Memo

Subject: Covenant Living at the Shores 9150 Fortuna Drive SE – List of Pre-App Questions

The project team would like to submit the following questions for discussion at the pre-application conference for the proposed Covenant Living at the Shores Redevelopment Project:

# Average Building Height Calculations

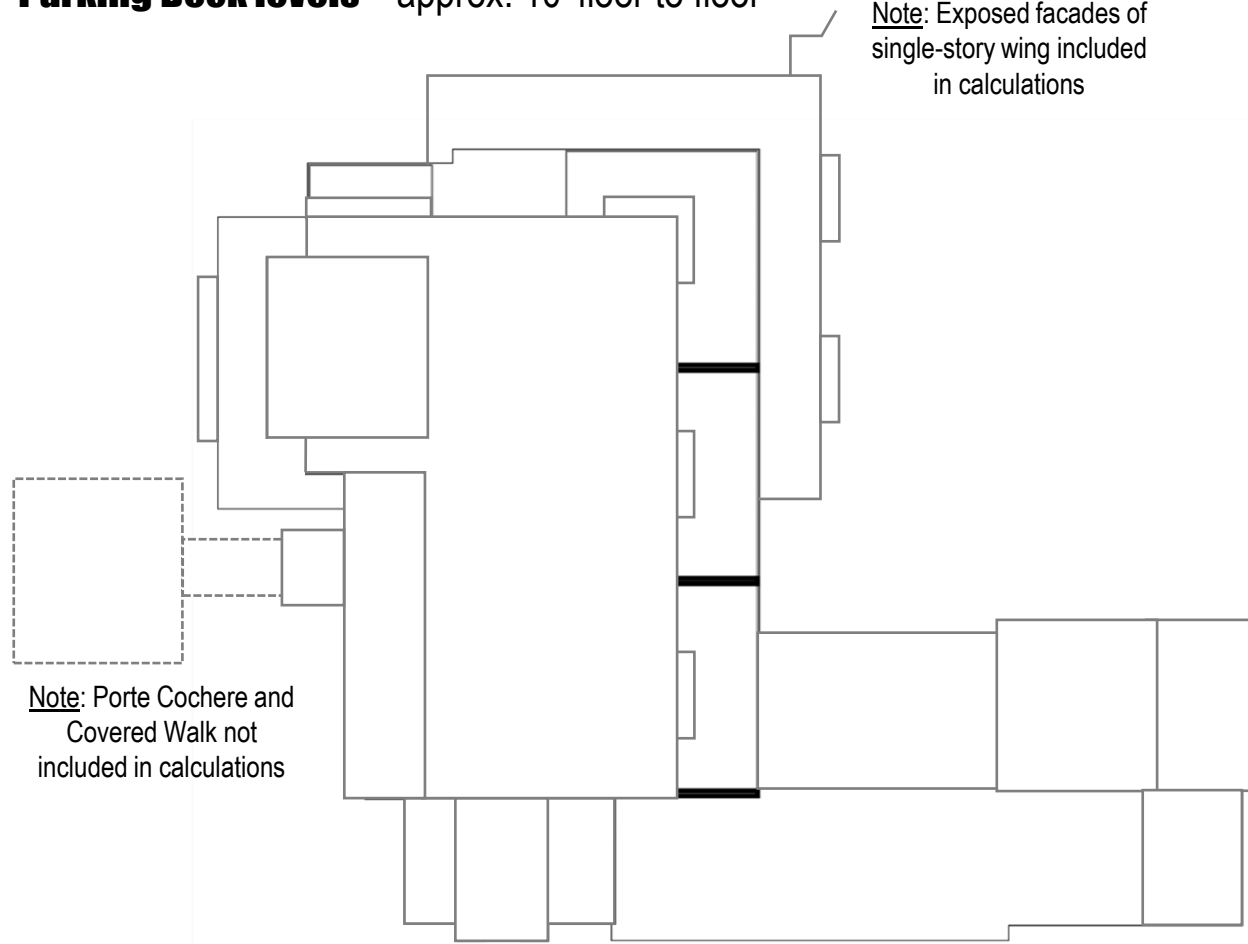
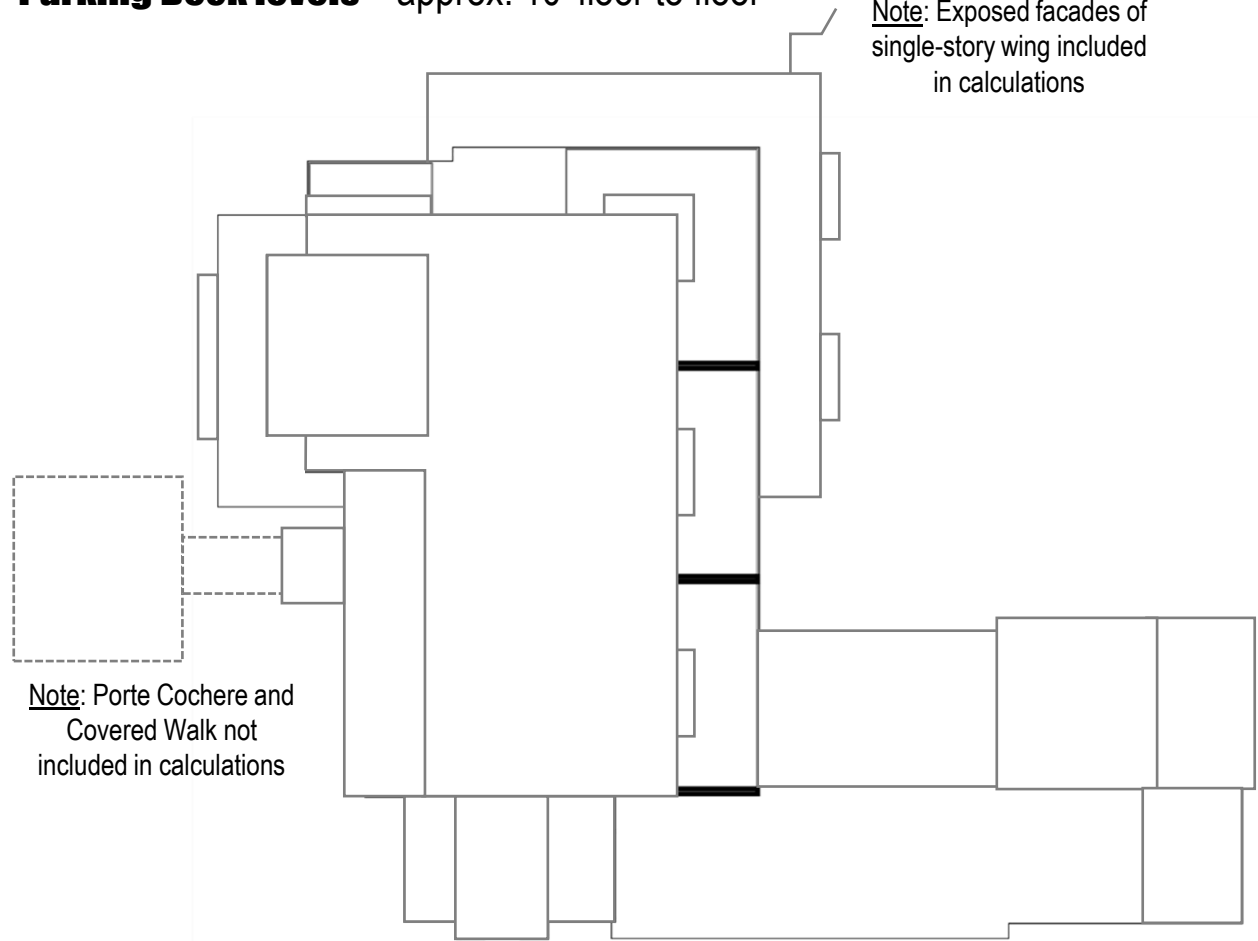
3. Please review the provided building height calculations and confirm if the correct method of calculation was utilized or provide guidance as to the required method.

4. Please confirm if “base of a building façade” is considered grade or a roof/terrace where a façade is set back.
5. Does tiering or terracing the building mass affect the assessment of number of stories (base building stories allowed vs. maximum allowable building stories)?

**FIRE SERVICE PLAN**

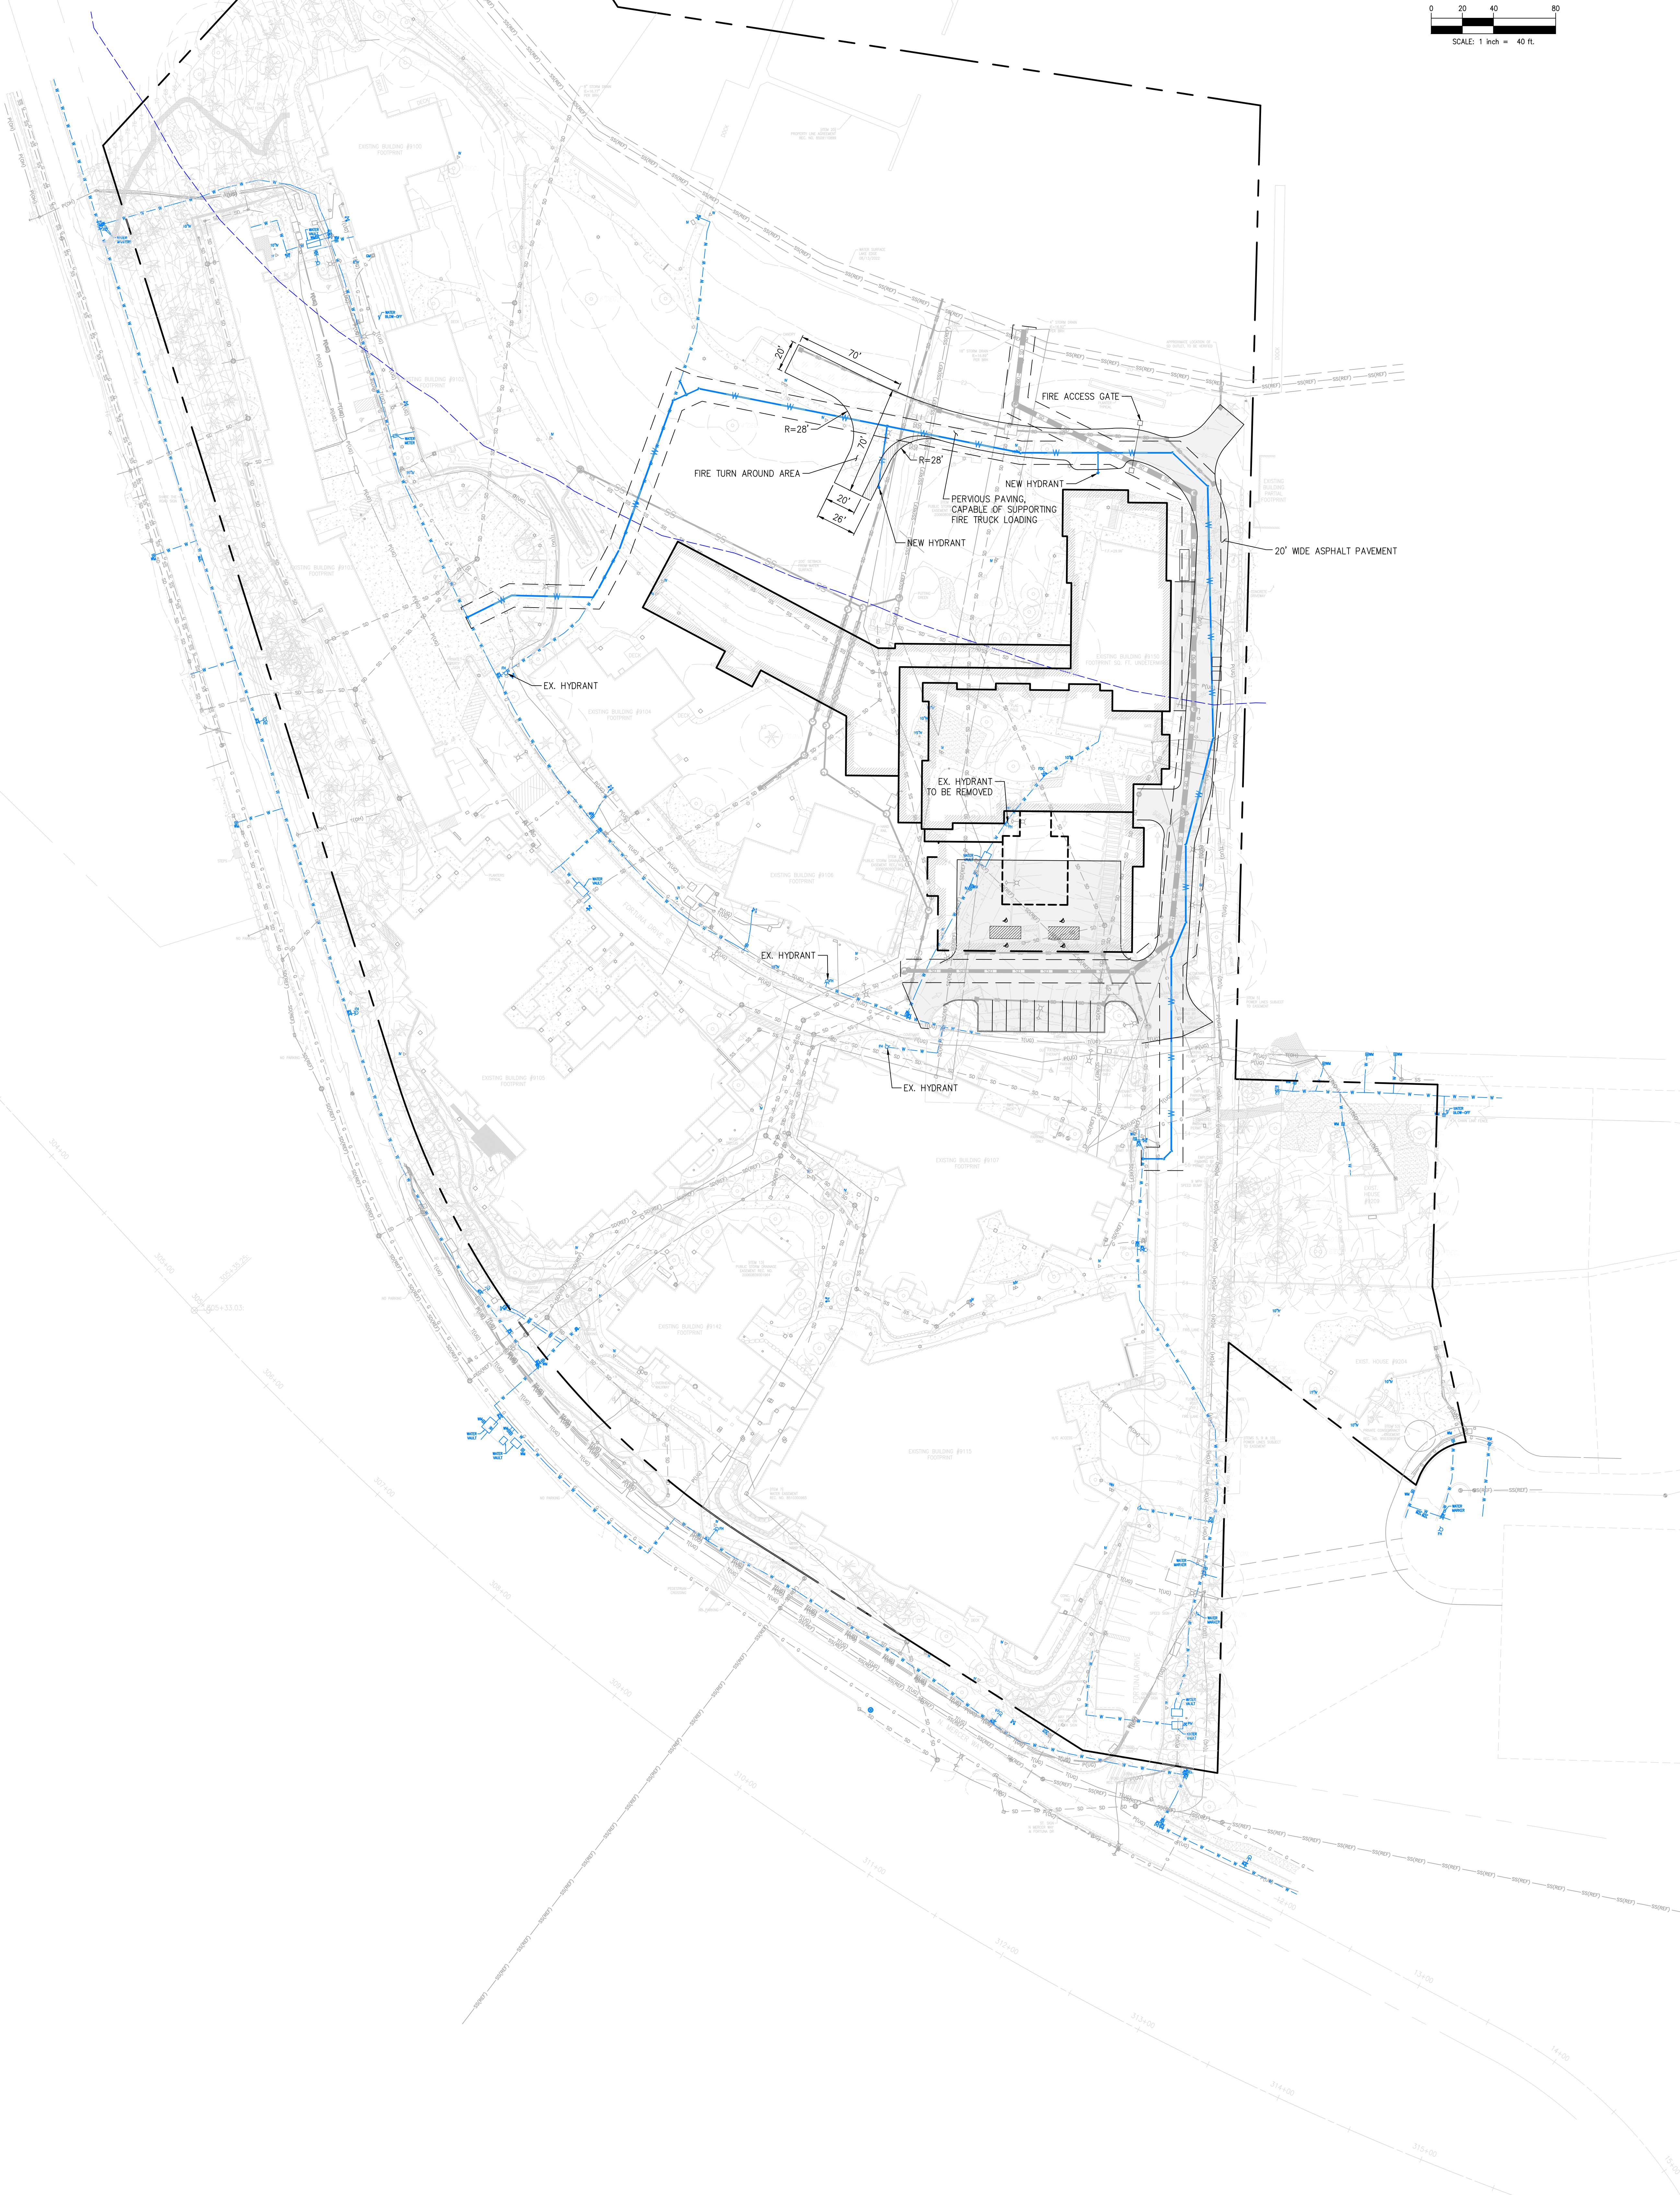
6. How are the number of stories determined; at the main entry or ground floor or worse case location or lowest grade?
7. Will the new fire water loop and fire hydrants be considered public or private? If private, please describe any additional requirements (e.g. backflow prevention at the new tees to the public main).

8. There will be a gate just west of the service vehicle turnaround at the NE corner of the site, limiting the north access drive aisle to be fire only. The following questions pertain to this drive aisle.

- a. Can the pavement material be Grasscrete or similar “green” product that will support the fire truck loading?
 - b. Can the surface west of the gate be excluded from water quality treatment requirements since the surface will be infrequently utilized (fire only)?

- c. Please confirm fire access requirements are met with this fire lane location and associated fire hydrants.
9. The project will pursue a Shoreline Conditional Use Permit (SCUP) after this pre-application meeting. The last pre-app notes indicated a Shoreline Variance and Substantial Development Permit might be needed. Can the city confirm if the Shoreline Variance and Substantial Development Permit are required?

## STORM DRAINAGE AND UTILITY EXHIBIT

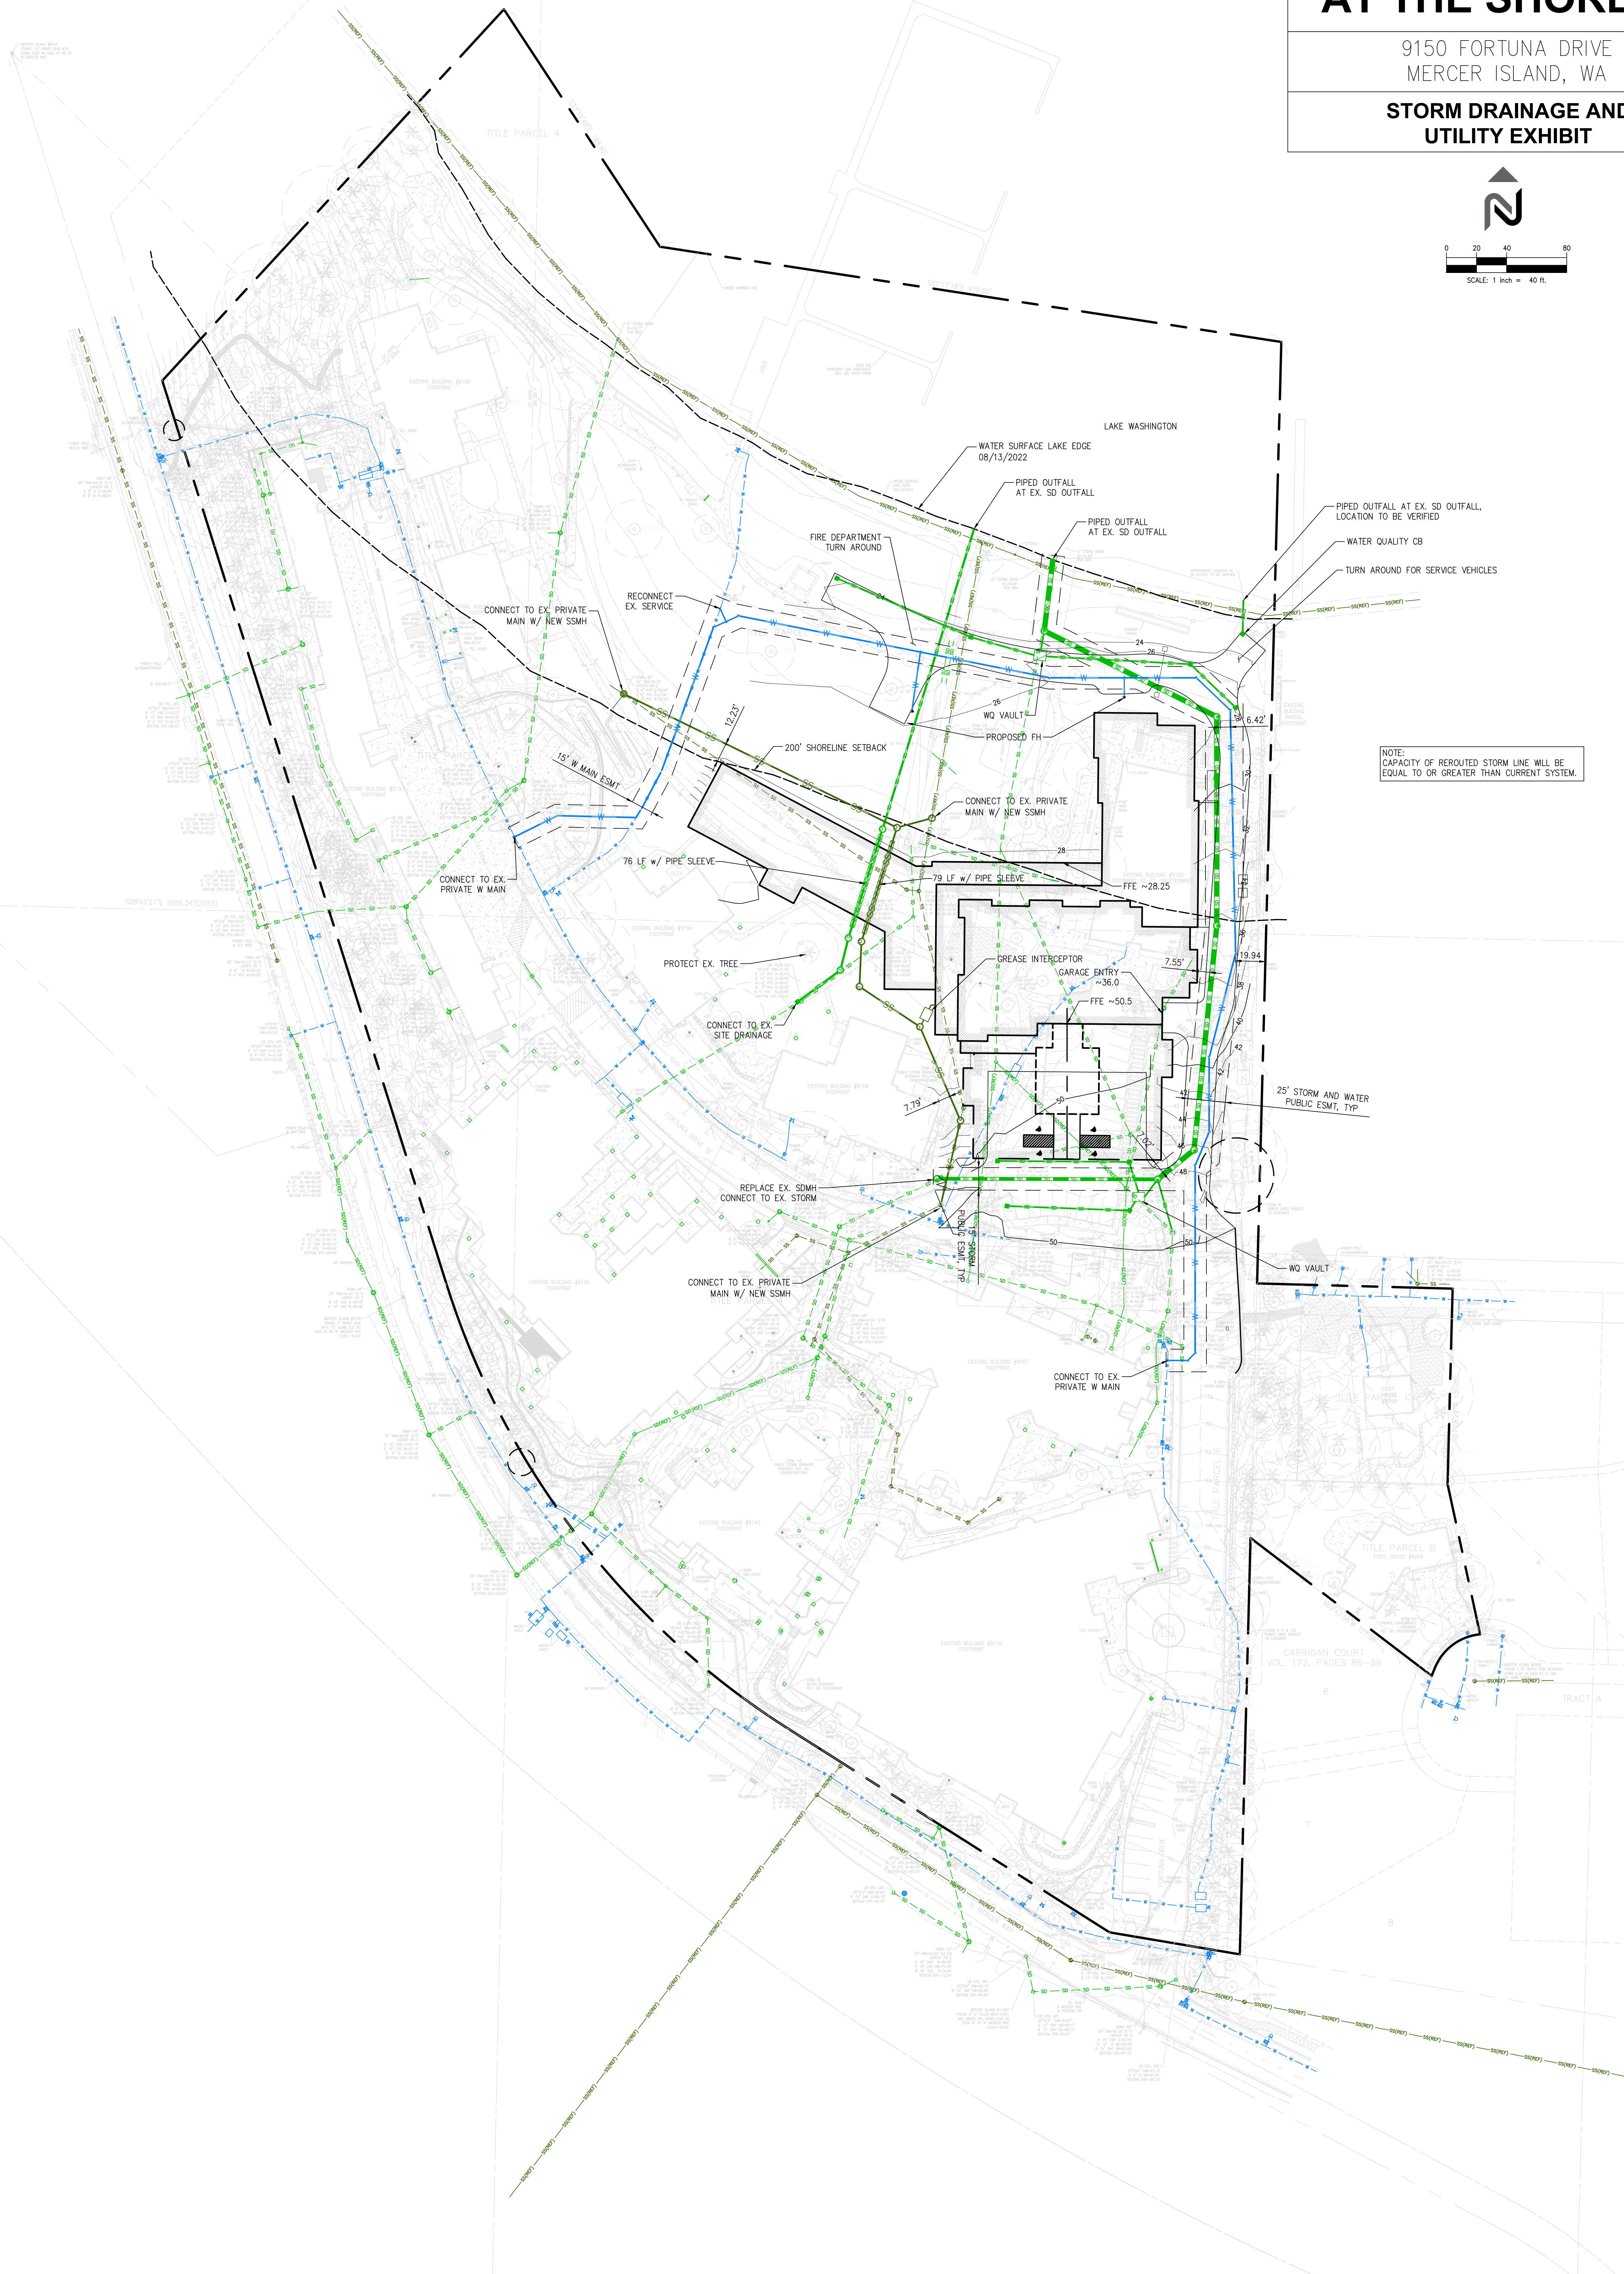
- c. Should the Shoreline Variance and Substantial Development Permit submittals be made concurrently with the SCUP?
10. The proposed storm drainage relocations include combining two public drainage lines into a single public drainage line that discharges at the existing piped outfall to Lake Washington, but with a larger outfall. Can this be permitted through the Building Permit process?

11. The proposed private storm drainage relocation layout includes routing the new storm drainage pipe below the new building, protecting the pipe within a steel pipe sleeve. Does this City have any objections to this routing?

12. The proposed private sanitary sewer relocation layout includes routing the new sanitary sewer pipe below the new building, protecting the pipe within a steel pipe sleeve. Does the City have any objections to this routing?
